RE: 3/2026/0587 – PLANE TREE FARM, CHIPPING ROAD - OBJECTION

[REDACTED]) write to formally comment, and object, to the application above which seeks planning permission for an earth banked slurry lagoon and the erection of a safety fence.

Planning application 3/2026/0587 - Construction of an earth banked slurry lagoon and associated landscaping, Plane Tree Farm, Chipping Road, Chaigley BB7 3LT

OBJECTION

Figure 3- Illustrative site plan

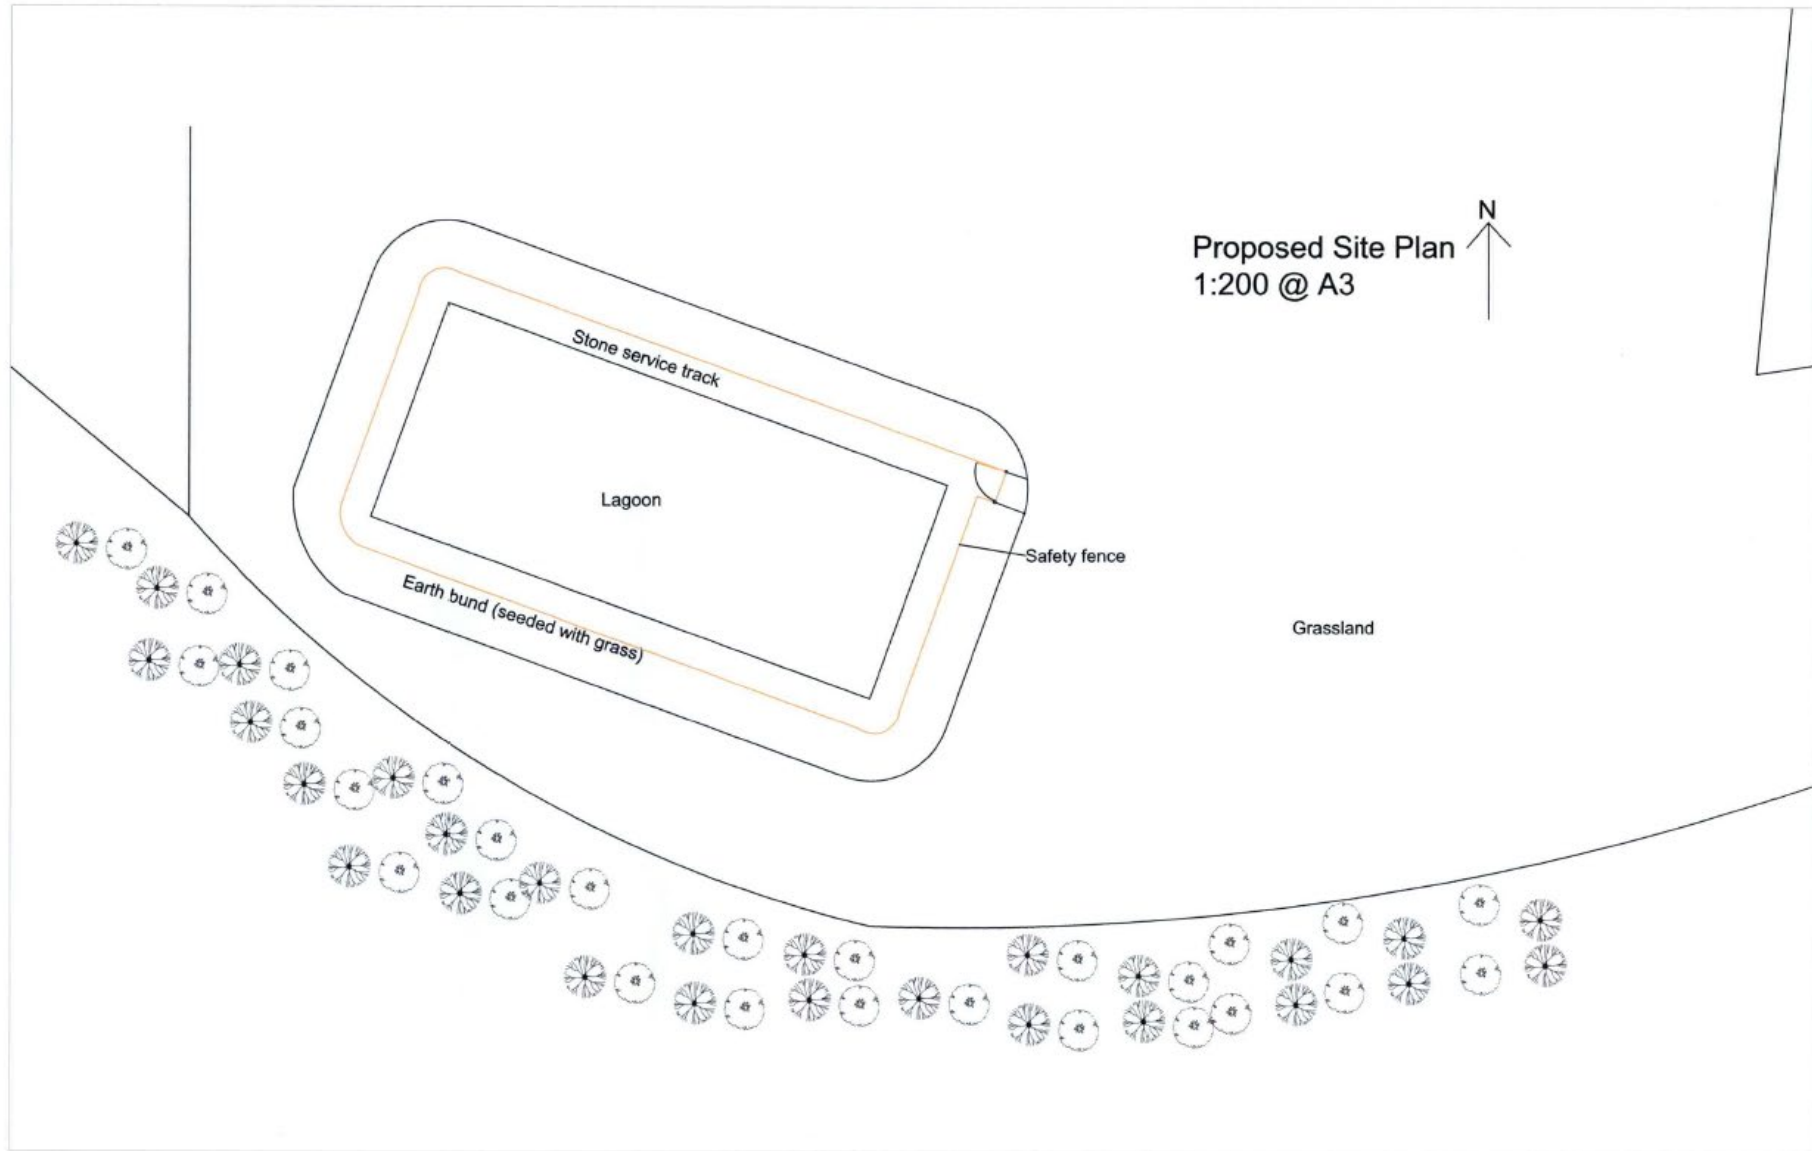
Furthermore, the suggestion of planting trees in close proximity to the proposal is of notable concern given the potential for trees roots to, over time, jeopardise the integrity of a lagoon and its (unspecified) liner.

The landscaping scheme proposes 75 trees at 3-metre centres close to the lagoon but states no minimum root-protection offset from the liner or toe of the embankment. The applicant's own AHDB guidance warns that trees, scrub and roots must be controlled around earth-banked stores. A

Sections
Scale 1:250 @ A3

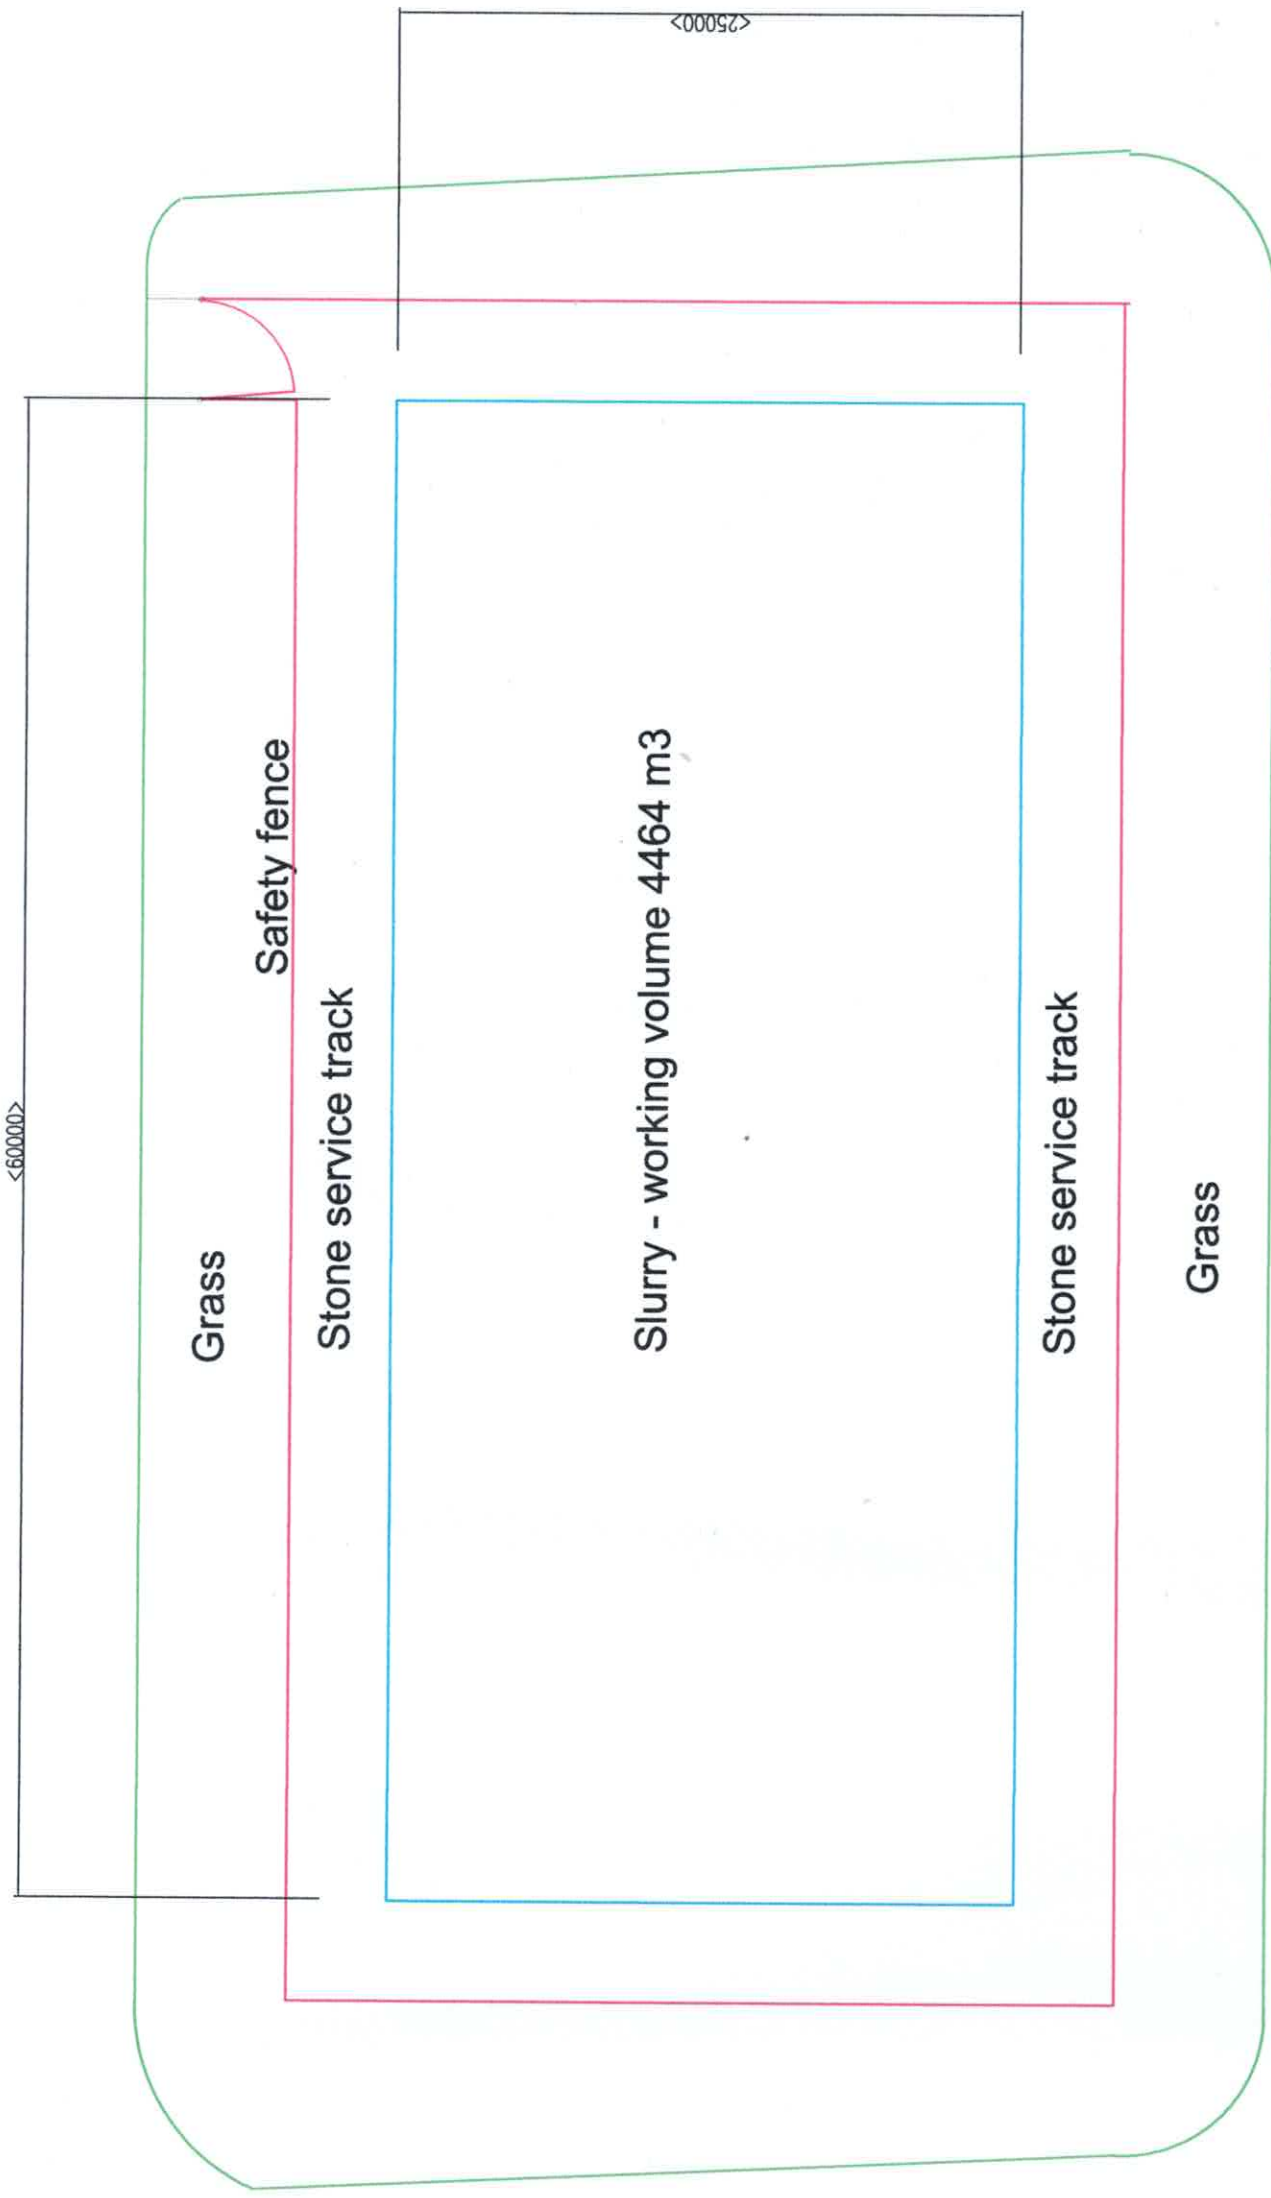
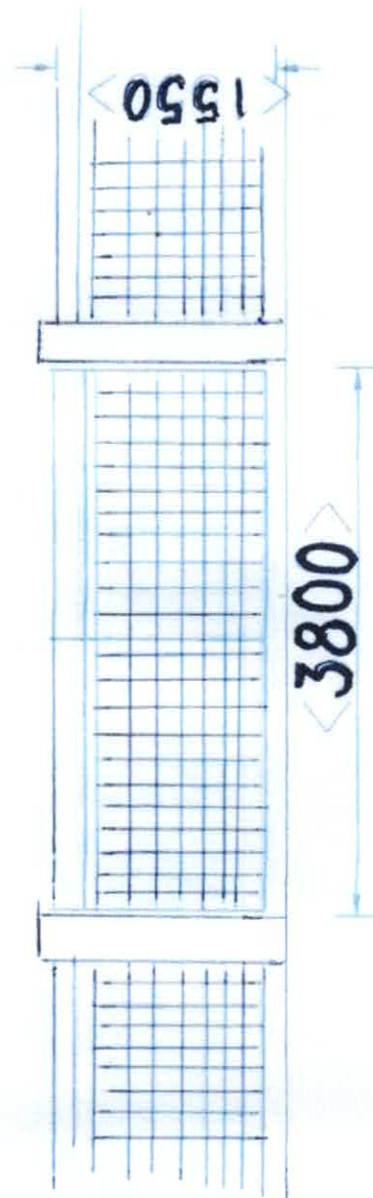
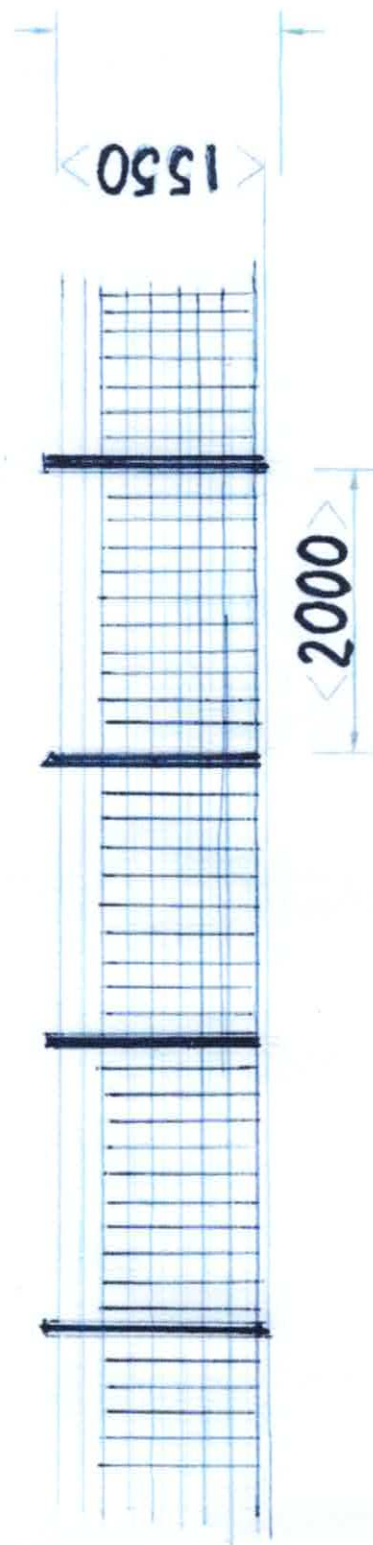
The sectional plans provided show a depth of 5.75 metres (including a 0.75 metre freeboard) with the plans confirming a working storage volume of 4,464 cubic metres. The slurry wizard calculations state a total depth of 5m (assumed after freeboard).

The size of the lagoon has been understated within the design and access statement referring to the proposal being no more than 2 metres above ground level. The cross-section shows the embankment to be in the region of 3.5 metres on the side facing the Hamlet due to the ground sloping away which would be combined with a 1.55 metres fence on top, resulting in an overall height of development in the region of 5 metres further exacerbated by the topography of the area with the lagoon being above the height of the nearest dwellings.

The sections plan fails to show the proposal in the context of the surrounding site levels taking into account the sloped topography and its height relevant to dwellings that are situated less than 100m from the application site.

The cross section of lagoon provided shows the lagoon to be in the region of 3.5 metres below the current ground level with trial holes stated to be undertaken to a depth of 4 metres. The Environment Agency was clear that testing was required to be undertaken for at least a metre below the lowest point of the lagoon to ensure appropriate ground type.

5. **Potential harm to the Forest of Bowland National Landscape.** The undated sections sheet, scaled against its own 5 m depth dimension, indicates a downhill crest around 3.5 m above existing

The DAS says the bund will be "no more than 2.00 m above ground". The submitted "Sections Plan Safety Fence" sheet is undated and bears no drawing number. Its E–W section crosses falling ground and does not dimension the crest against existing levels; scaled against the stated 5,000 mm lagoon-depth dimension, however, the downhill crest appears to be about 3.5 metres above existing ground. With the 1.5-metre safety fence, the overall height approaches 5 metres. No datum or reduced levels are given to reconcile this with the DAS. The applicant's landscaping scheme says planting is intended to screen views to the west, acknowledging a visual effect in that direction, yet no landscape and visual assessment or verified viewpoints from Walker Fold and the surrounding roads or paths have been submitted. The proposal is an isolated engineered structure in open pasture rather than a feature contained within the farmstead.

- Height: "no more than 2.00 m above ground" (DAS) against an undimensioned sloping-ground section that, when scaled, indicates roughly 3.5 m on the downhill side.

Test Hole images - 26th March 2026

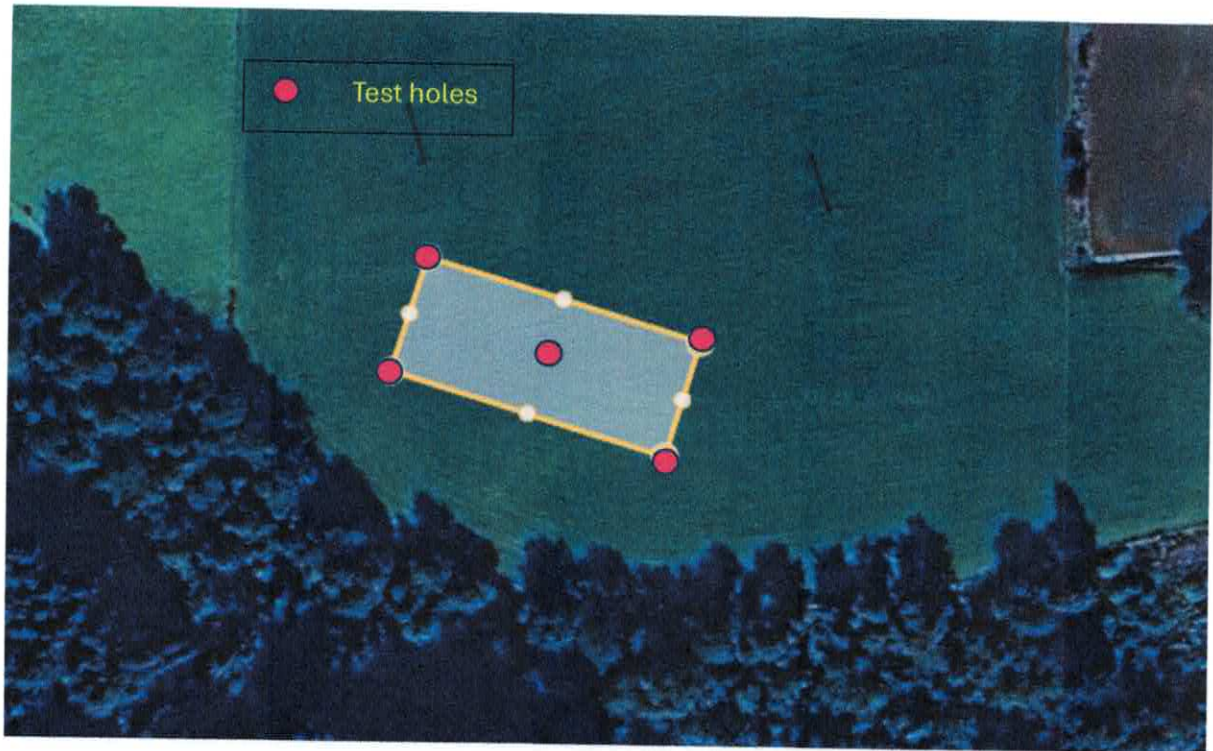
The laboratory sample description sheet states sample depths at 0 metres based upon “B” (large disturbed (bulk) sample). There is no confirmation, therefore, as to the depth of the samples which have been tested in line with the guidance and advice provided by the EA prior to application. The submission states that test holes were excavated to 4 metres with samples taken at approximately 1 metre depth intervals for laboratory testing, however, only five laboratory samples are provided in terms of results which equates to 1 sample per test hole which does not match with the test hole approach stated within the overall submission.

The site investigation cannot be checked against the applicant's own guidance. AHDB Factsheet 5a requires trial pits to extend one metre below the expected final store base, with the water table observed below base level, preferably during the wettest time of year. The sheet headed "Test Hole images - 26th March 2026" says five holes were excavated to 4 metres and samples taken at approximately one-metre intervals. However, it supplies photographs rather than an individual log for each pit: there are no surveyed pit coordinates, dimensions, strata logs, weather records or recorded groundwater/seepage observations. The undated sections sheet provides no datum or reduced levels for the lowest lagoon base, so it is impossible to verify that every pit reached one metre below that level. The IGNE report says the samples were received on 13 May 2026 and that the laboratory had no control over sampling; the submission does not clearly correlate every result with a pit, position and depth. A single investigation date without seasonal groundwater evidence does not establish wettest-condition performance. The DAS's conclusion that the soils can provide a secure bund therefore cannot be independently checked from the submitted material.
